Subject: objection to Planning Application No. 3/2023/0540

I am writing following receipt of a letter to residents of Chapel Brow concerning Planning Application No. 3/2023/0540 from Nicola Hopkins. I wish to state my objections to the plans. I have been in discussion with neighbours and with your offices over many years now it is disappointing that yet again we must highlight our concern over numerous issues which appear to be in conflict with the original design principles and planning approval: 3/2011/1071.

Ref: Planning Application No. 3/2023/0540

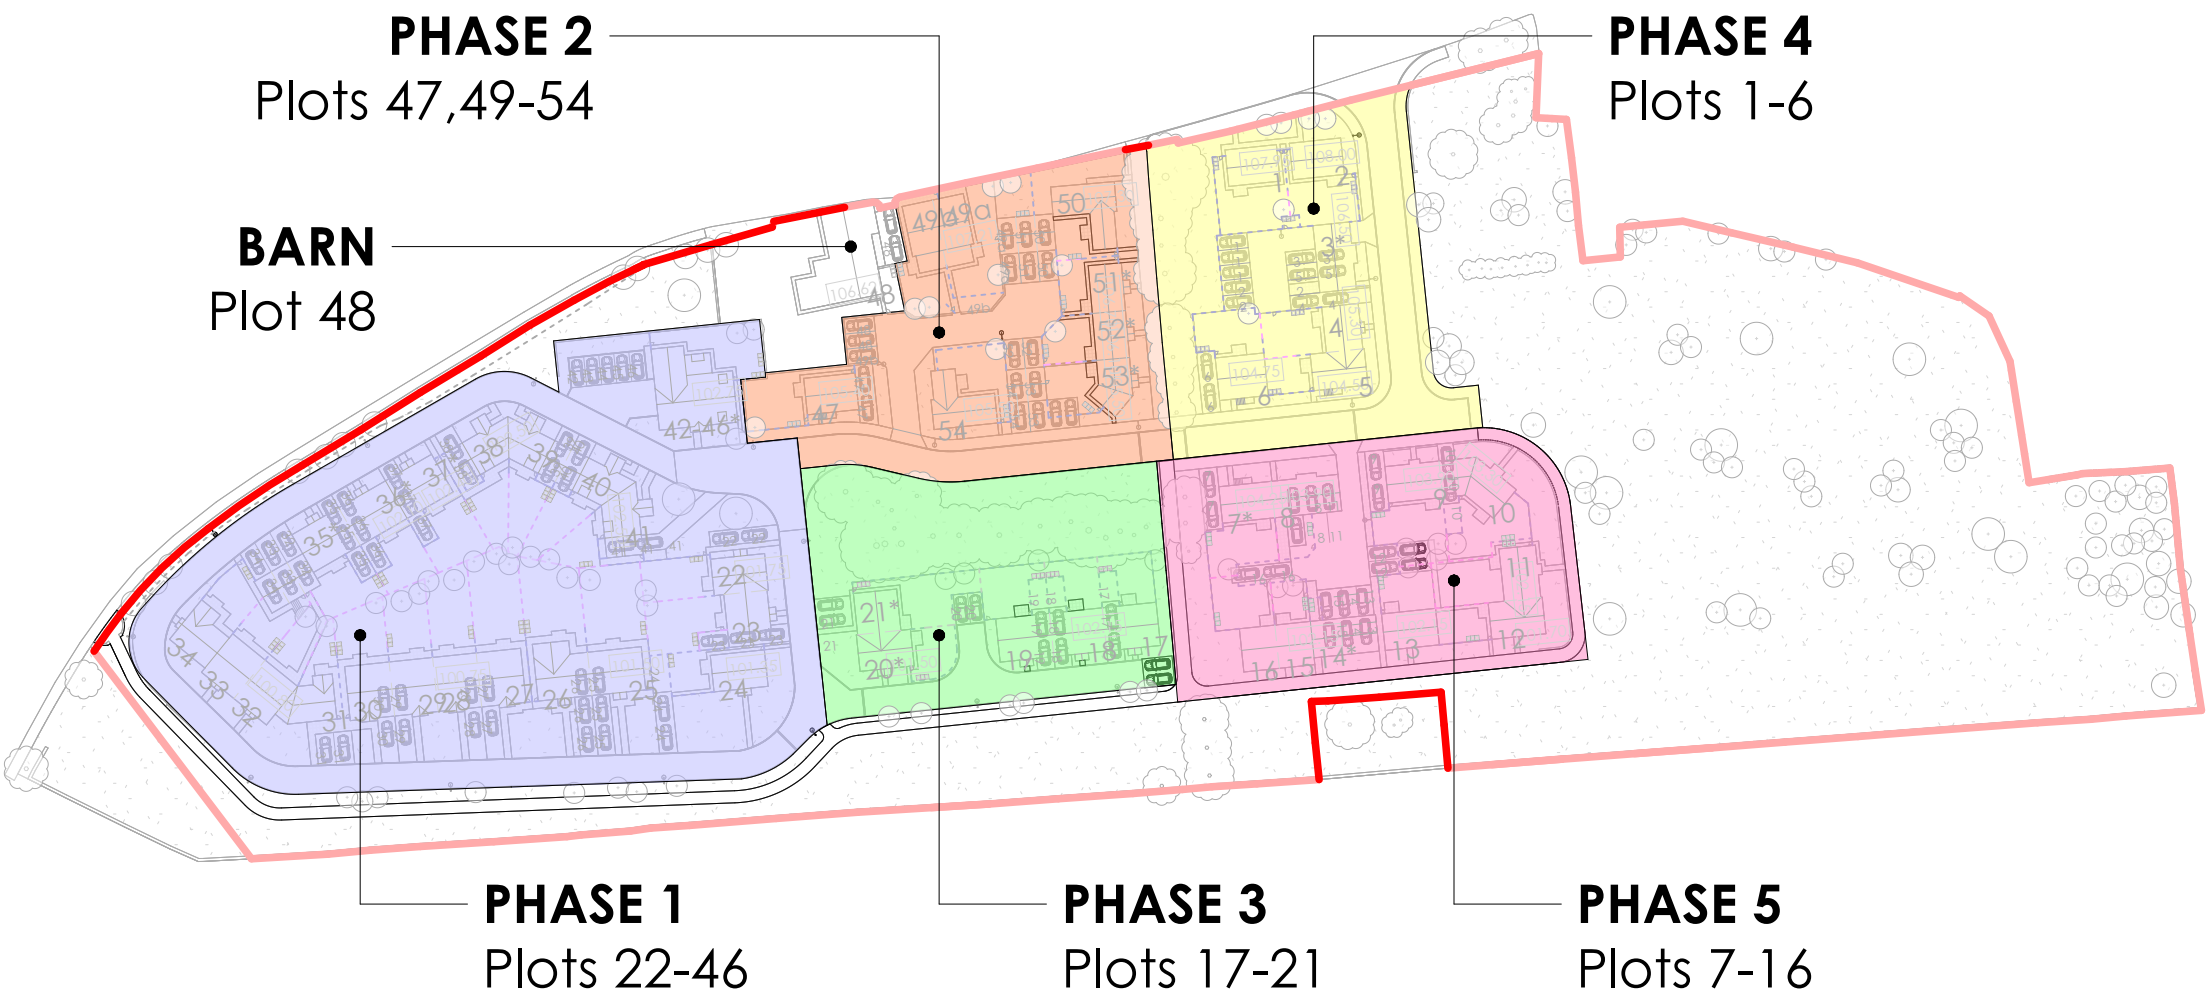
Upon closer examination of drawing CN-00-001 Rev J shows the removal of footpaths and access routes to, and through, the area and furthermore they intend to install a new fence, without breaks, which will effectively render the area closed-off from public access. The original scheme shows an access/egress pathway connecting to the bridle path adjacent the houses lower down Chapel Brow.

The fence line is clearly shown on the drawing extending from the new wall, yet to be built, adjacent the road at Chapel Hill down almost to the southern boundary adjacent the reservoir wall. This is already marked as a 'swale' on the approved landscape plan and is not now, and won't be on completion, an easy

Reference to Drawing No.CN-00-001 Rev G shows the earlier incarnation of the drawing with paths and access as defined in early planning approvals although the pond is omitted. Both drawings are in the same application package and it is very easy to miss the significance of the differences. It is puzzling that the marketing effort by Agents acting for the owner have emphasised the pond and the adjacent reservoir as an important feature to be valued by the new residents and the wider community. How odd for such a reversal of attitude. This totally contradictory affair causes me to wonder what may be behind this planning application to seek RVBC approval for these changes.

Inspection of the new drawing Rev. J named above says:- 'Green space to be returned to existing site levels as indicated.' There is an arrow pointing to a named level that happens to be at the original level provided by Survey Operations to United Utilities. The other levels on this drawing version J, shows figures which I take to be extracted from that original survey. At the lower levels near the south boundary wall at the reservoir it shows levels of 100 plus/minus decimal points. This indicates a gradual slope from top to bottom of about 3M.

There is no mention of this removal elsewhere in the application by way of verbal or written confirmation that what they infer in their one line arrowed statement means that removal of all unlawfully dumped spoil will be removed from site. Therefore by pointing to one level that has not been unlawfully altered one could deduce that some mischief is at play. I am aware that RVBC are in contact with other residents of Chapel Brow who have become involved with more detailed affairs than I express here although my reasoning cannot be faulted.
